From: Charlotte Easton
Sent: 20 December 2018 11:49
To: Karen Parsons
Subject: FW: FW: BR/236/18/L - Esmonde House, Flat 3

I am e-mailing regarding our earlier telephone call today re: BR/236/18/L - Esmonde House, Flat 3. The Conservation Officer's comments are as attached and of note are the following comments:

PROPOSED 'CONSERVATION TYPE' ROOF WINDOW, AND
110mm Ø PIPE FOR STORM WATER

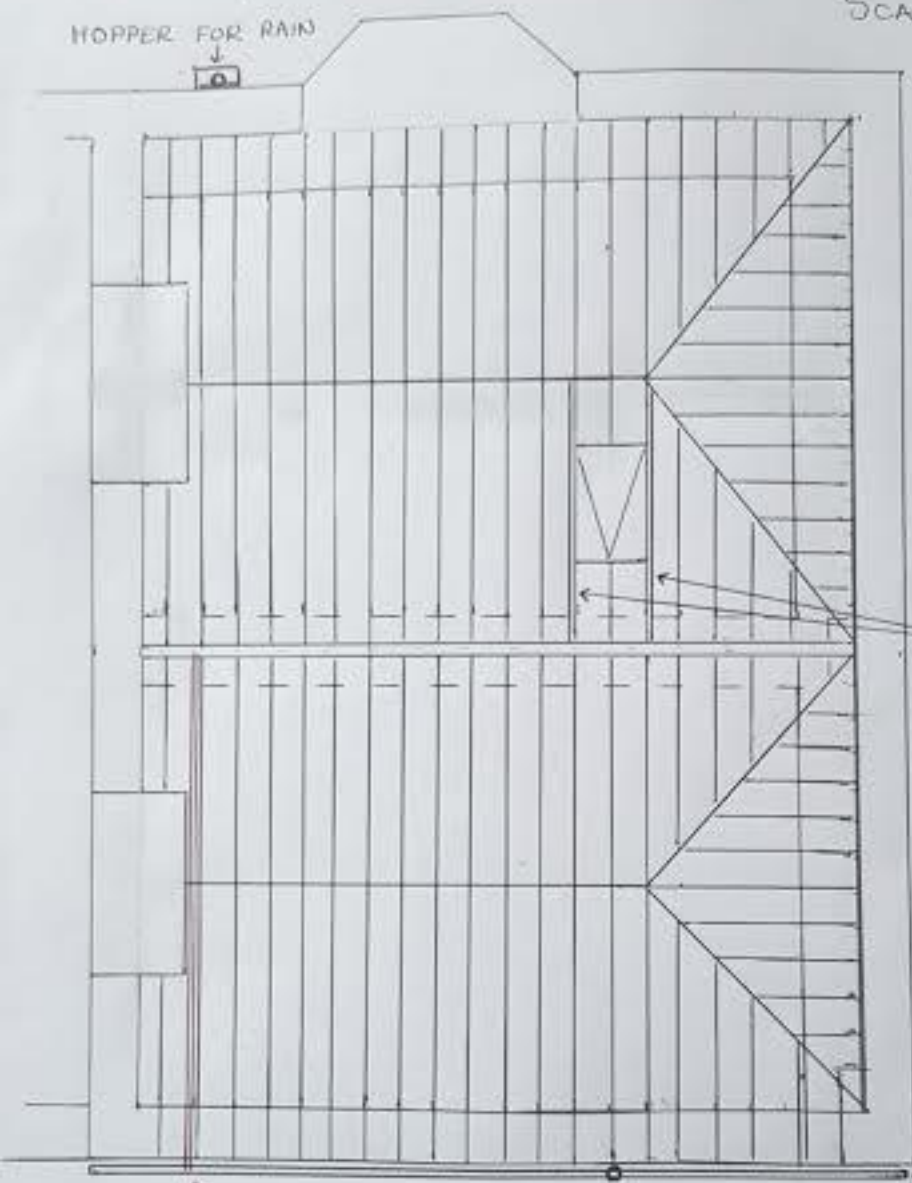
I also confirm the roof window will be of "conservation" style / standard... I would just like to confirm that this may be double glazed,??? as it is on the roof in hidden valley and will not be in sight.

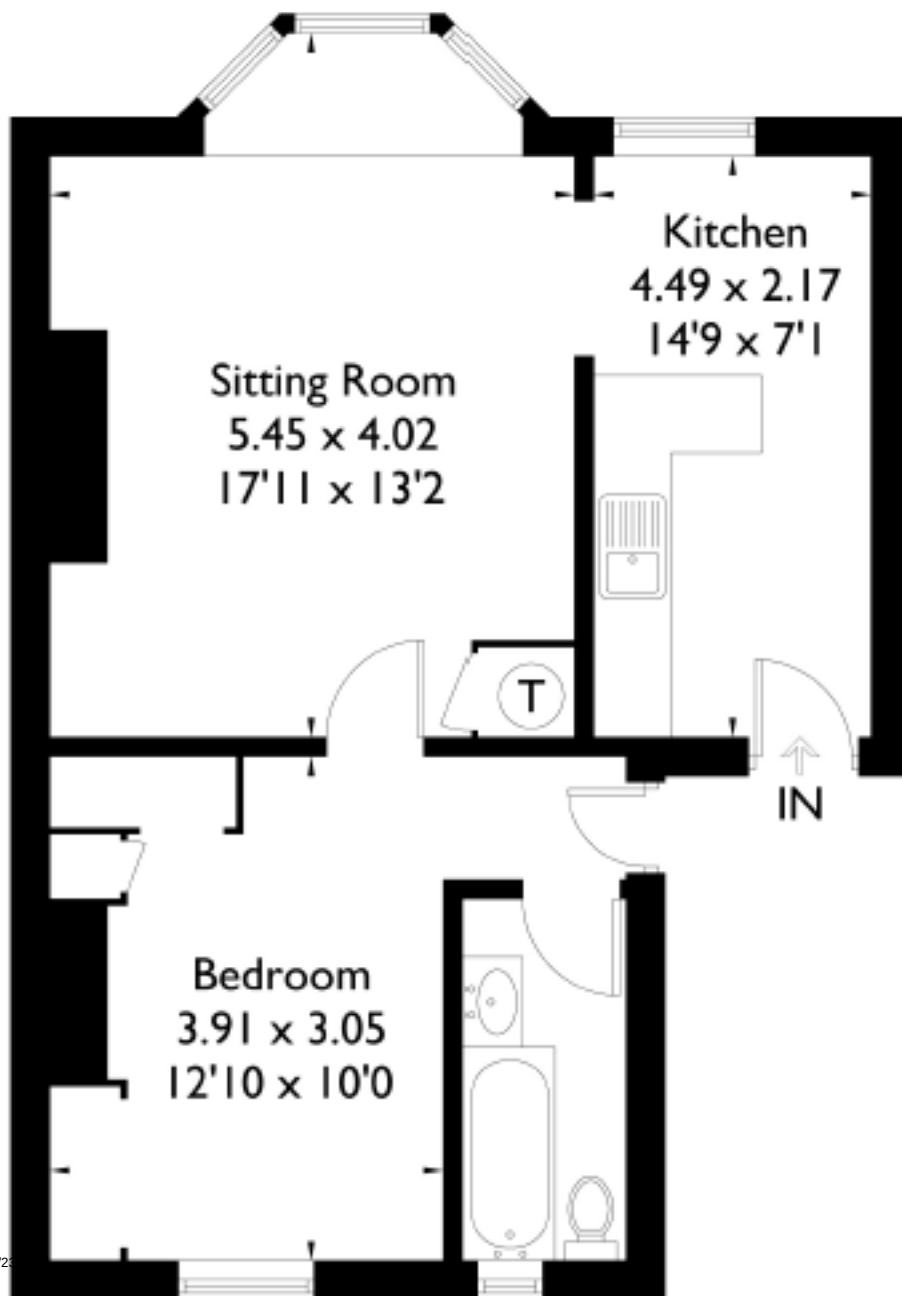
'The replacement of the windows identified on the plan is considered to be acceptable; as they appear to be in a poor state of repair. However, I note that reference is made to upvc double

glazing on the proposed floor plans. Such a window type is not supported. All of the windows should be constructed in wood, and be single glazed.

Confirmation will need to be provided in order to ensure that the windows are to be wooden, and single glazed. The windows must also be the same colour as present.'

Additionally, while the plans state that the windows are to be replaced no details of the windows appear to have been provided regarding their design. It appears that no elevation plans and/or annotated photos have been provided detailing the windows as proposed and as existing.

I confirm I am in agreement to install wooden single glazed, standard / traditional sash windows where stated and to match front and painted white (one window to front of property - top floor above black coloured front door in picture attached, and the bedroom and bathroom windows to the rear).

The windows will have centre bars in the glass, as seen in existing front window. However, I would assume the narrow bathroom window would be better without a centre bar, if agreed.
